Bramford to Twinstead Reinforcement

Document 8.5.10: Applicant's Comments on Submissions Received at Deadline 2

Final Issue A
October 2023

STOUR VALLEY EAST  
 CABLE SEALING END  
 COMPOUND AT LITTLE  
 CORNARD

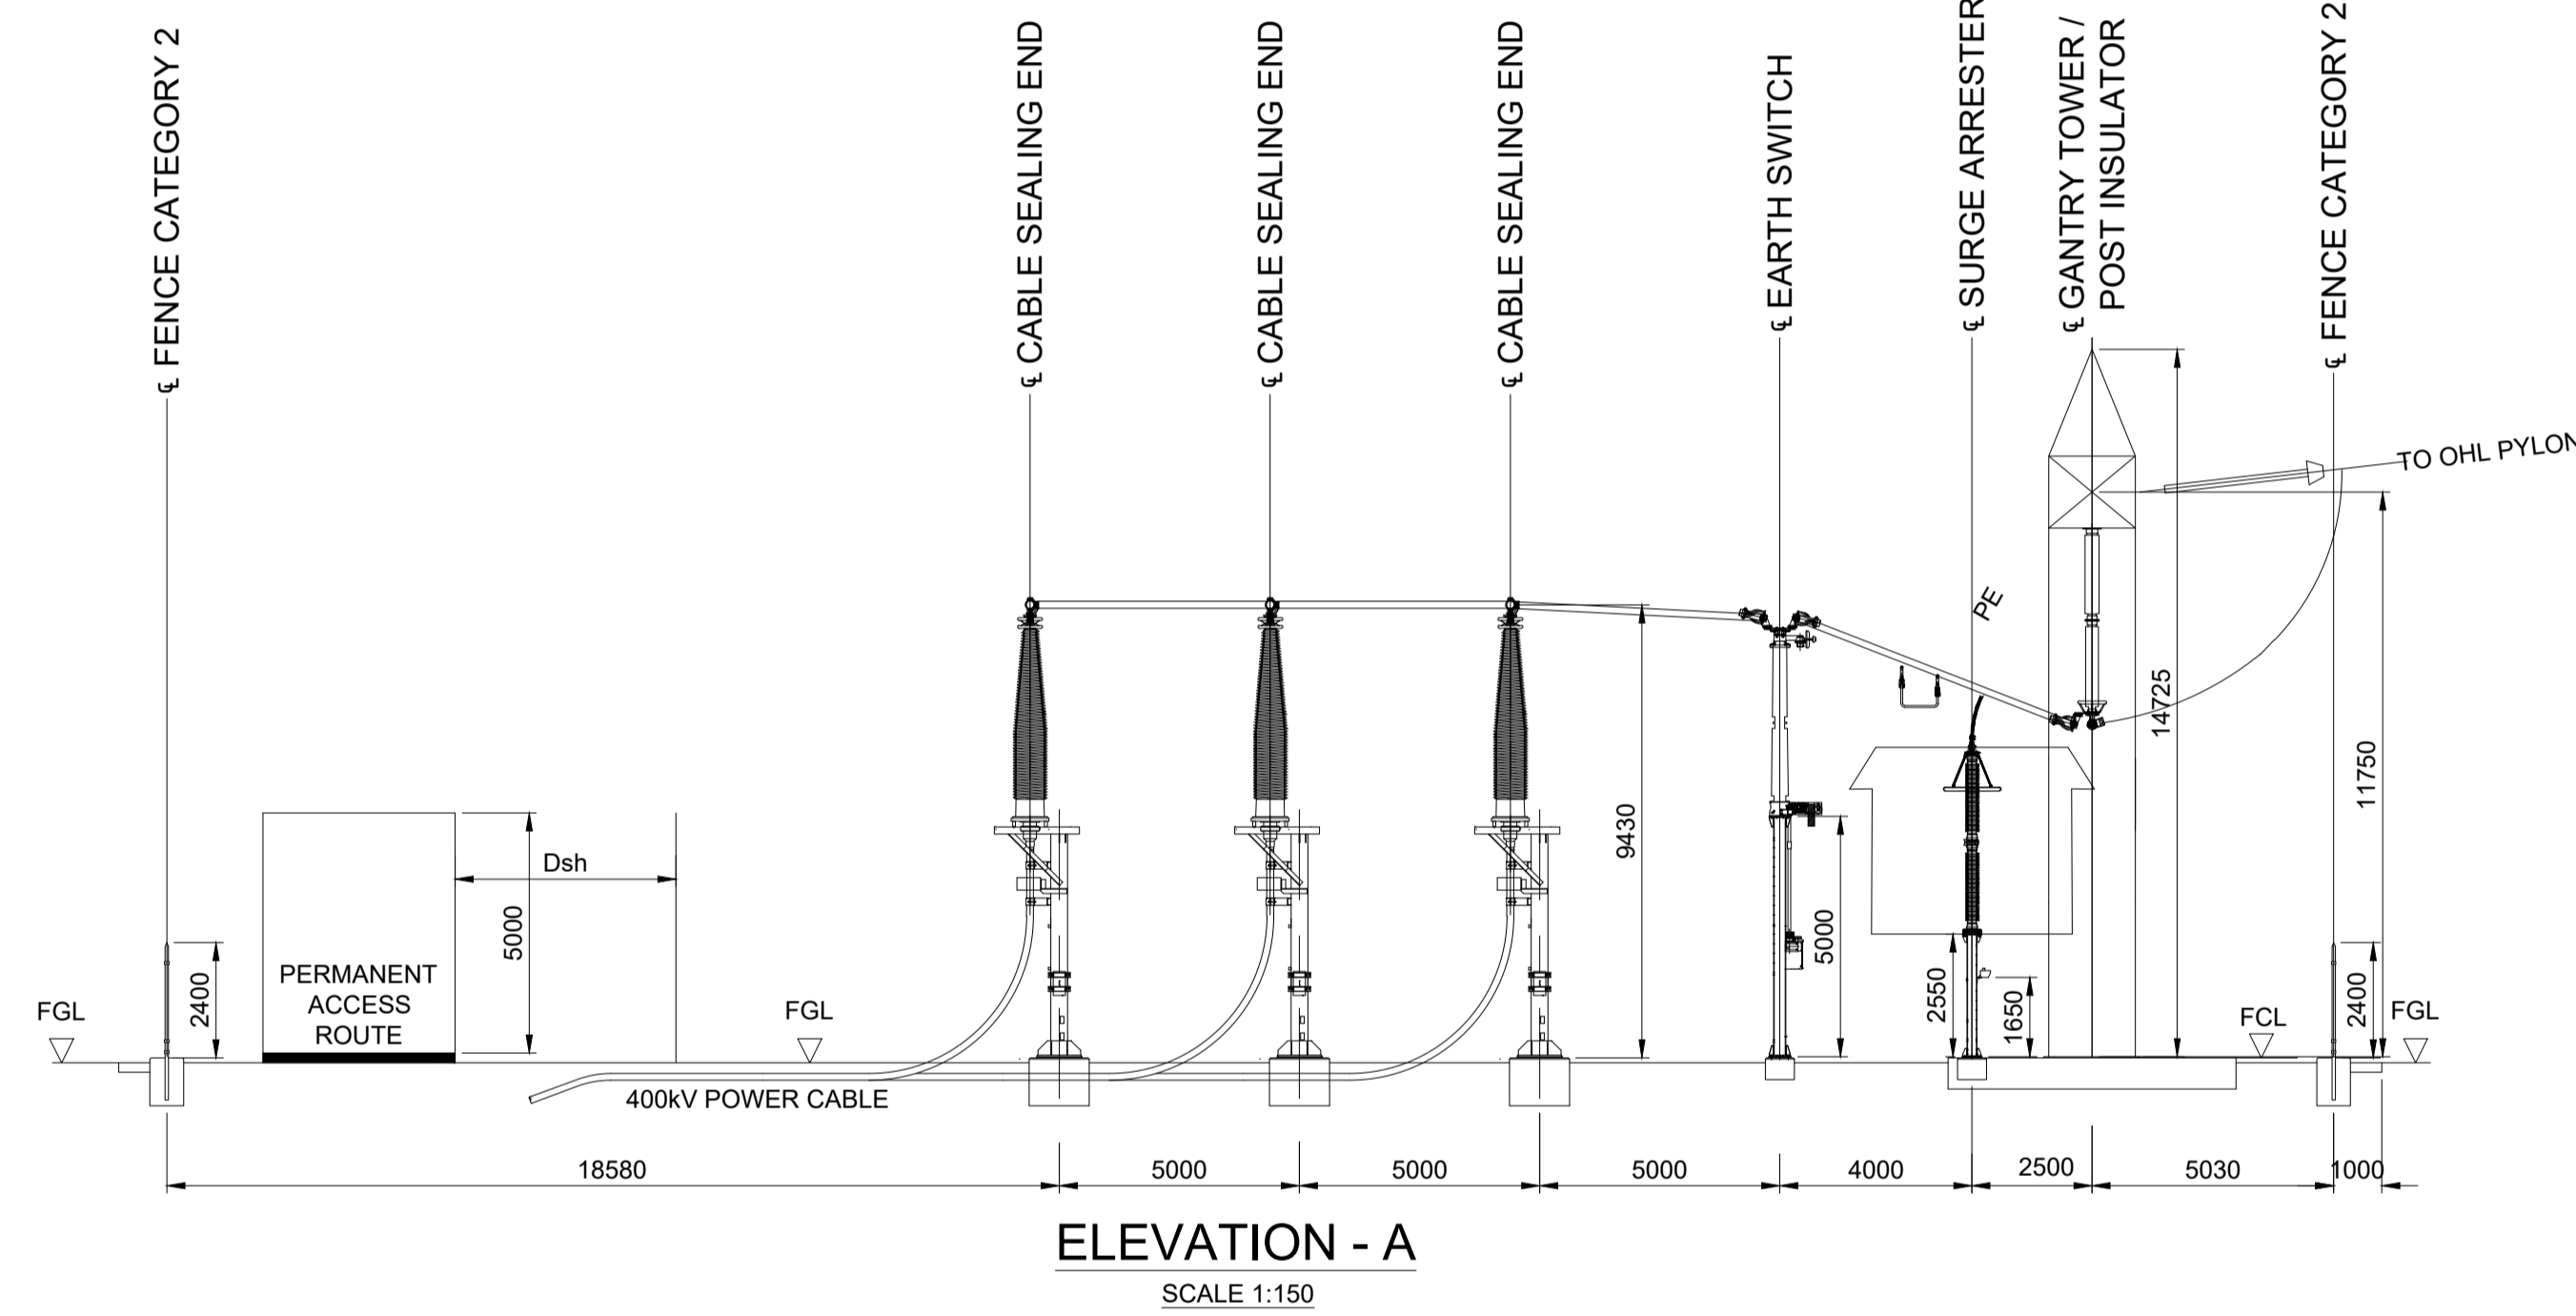
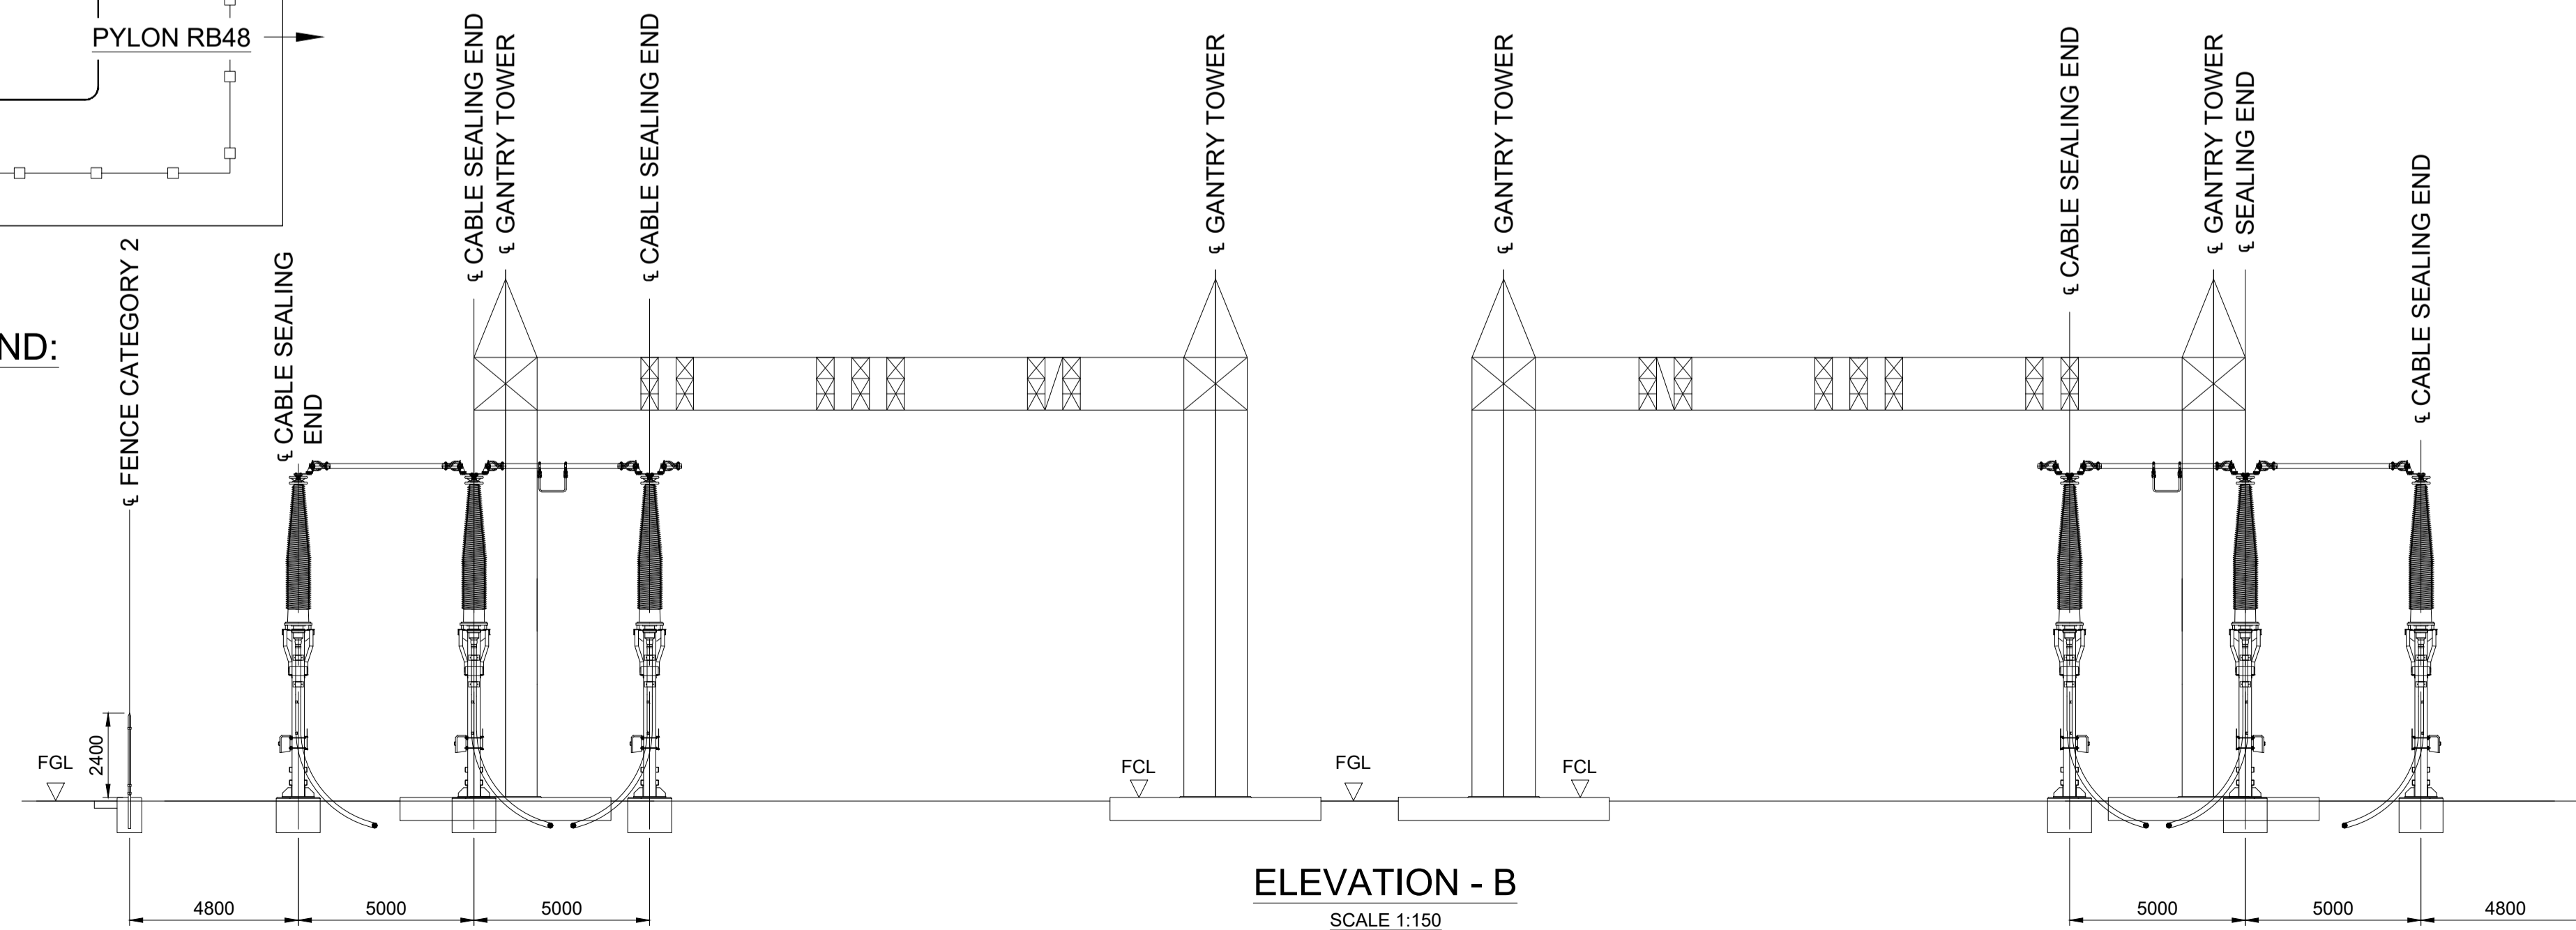
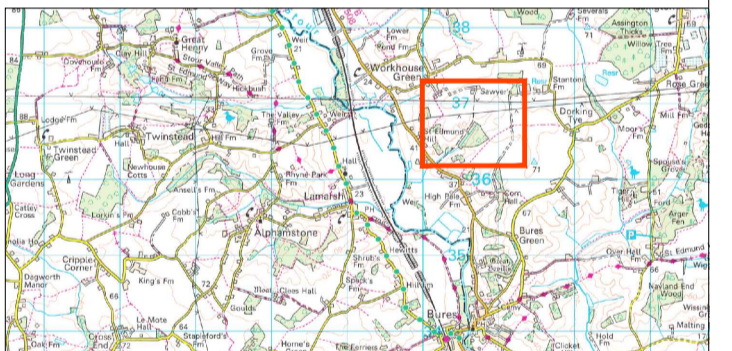
4.10	Stour Valley East CSE compound	BDC welcomes the additional undergrounding in the Stour Valley. The Council retains concerns that the assessment of the Stour	The Applicant has responded to these points in Chapter 2 of the Applicant's Comments on Babergh Mid Suffolk District

Reference	Matter	Point Raised	Applicant's Comments
		Valley East CSE compound has been considered at some distance from the facility therefore does not fully consider the experience of sensitive receptors using the PRoW network close by. As a result, there are concerns that any proposed mitigation or compensation will be insufficient to offset these anticipated adverse effects. BDC would like to see further assessment carried out from the PRoW network close to the facility and provision of a demonstrably effective mitigation and/or compensation scheme.	Council Additional Local Impact Report (document 8.5.3.3) and has no further comment to make at this stage.
